Arun District Council - Development
Control
Maltravers Road, Littlehampton, BN17
5LF

Reference: PA-0012760/01
Customer reference: LU/252/25/RES
12 October 2026

Approval of reserve matters following LU/47/11/ (as amended by LU/182/15/) for the remaining open space elements including playing pitches, changing rooms, car parking area, northern allotments and the eastern extent of the Black Ditch Open Space.

Environment Agency position

016 1 IN 100 YEAR PLUS 25% CLIMATE CHANGE
FLOOD ANNUAL PROBABILITY 1.85mAOD
1:1000

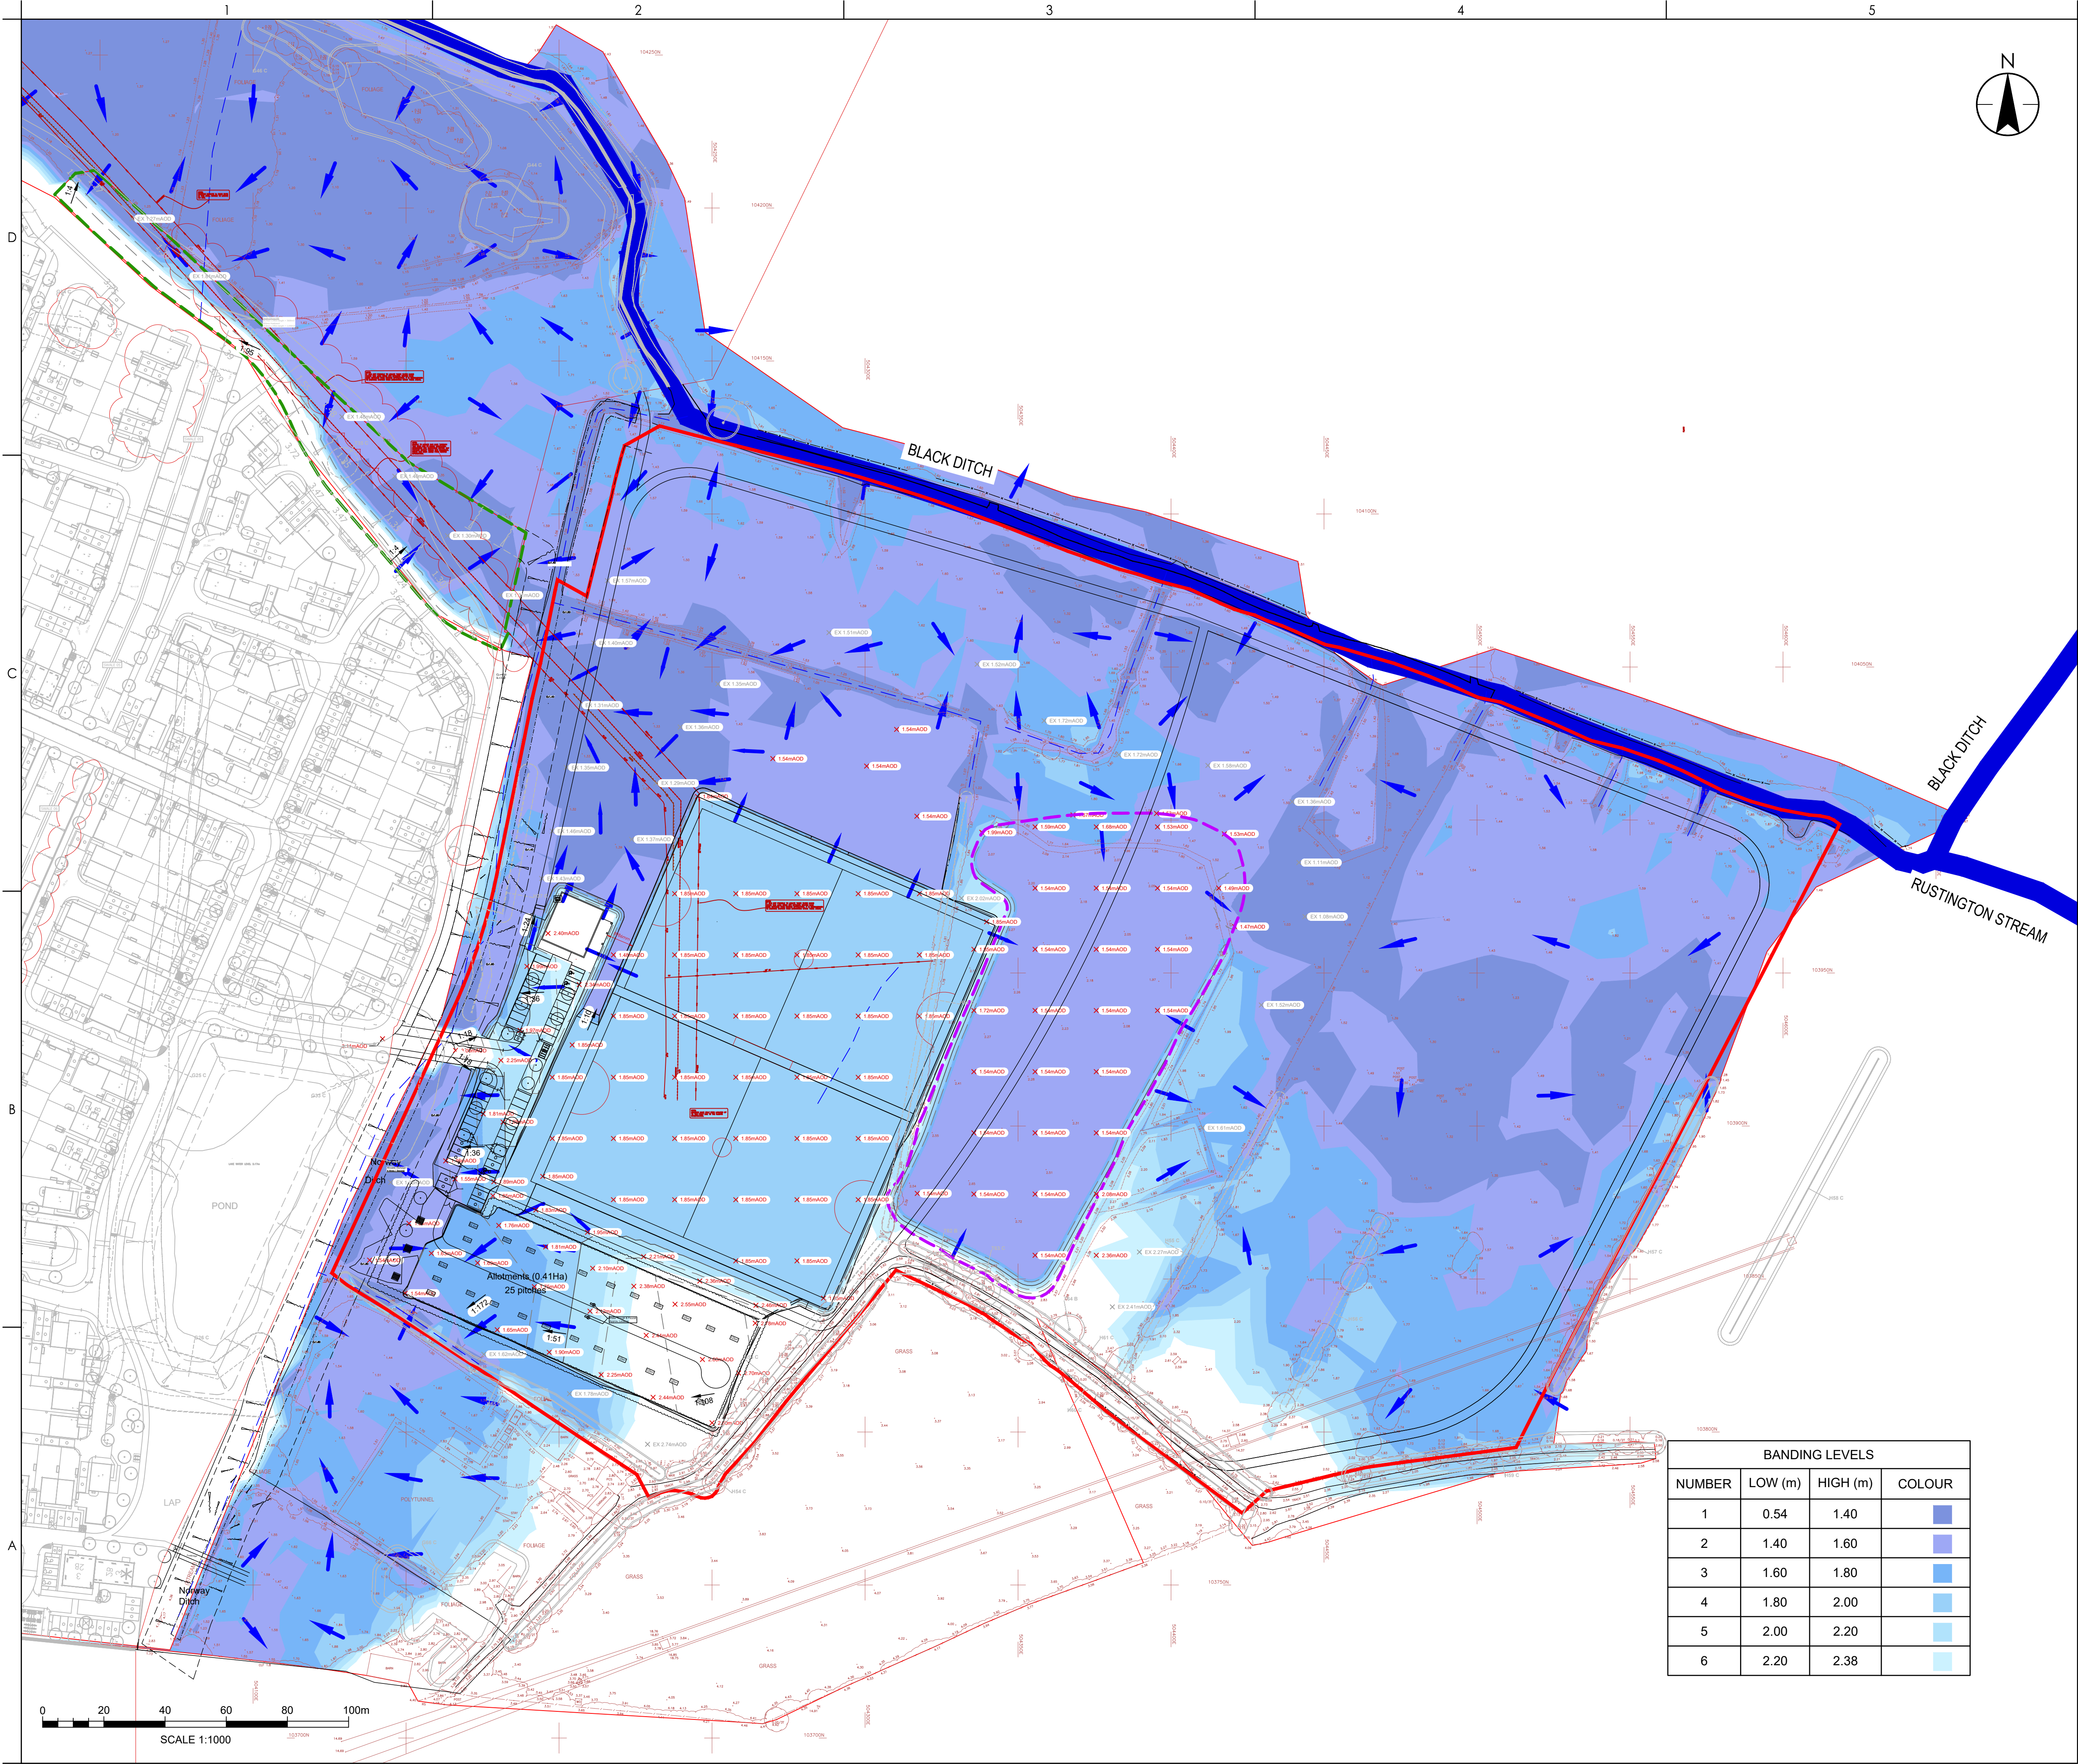
The drawing 'Engineering Layout Levels & Retention PHLITTLEOS.2/151 RevP2' appears to show variations in the post-development ground levels within the floodplain storage area when compared with 'PLAYING FIELDS FLOODPLAIN STORAGE ANALYSIS AND PROPOSED GROUND LEVELS 332612482/4001/016 REV P01.3'. These changes can be seen to the immediate north, west and east of the proposed changing rooms as well as to the proposed car park and area directly to its west.

The updated post-development ground levels are likely to reduce the available storage volume of the site. As a result, the previously submitted floodplain compensation calculations and supporting details may no longer be applicable.

To overcome our objection, the applicant should submit revised details for the updated flood compensation area.
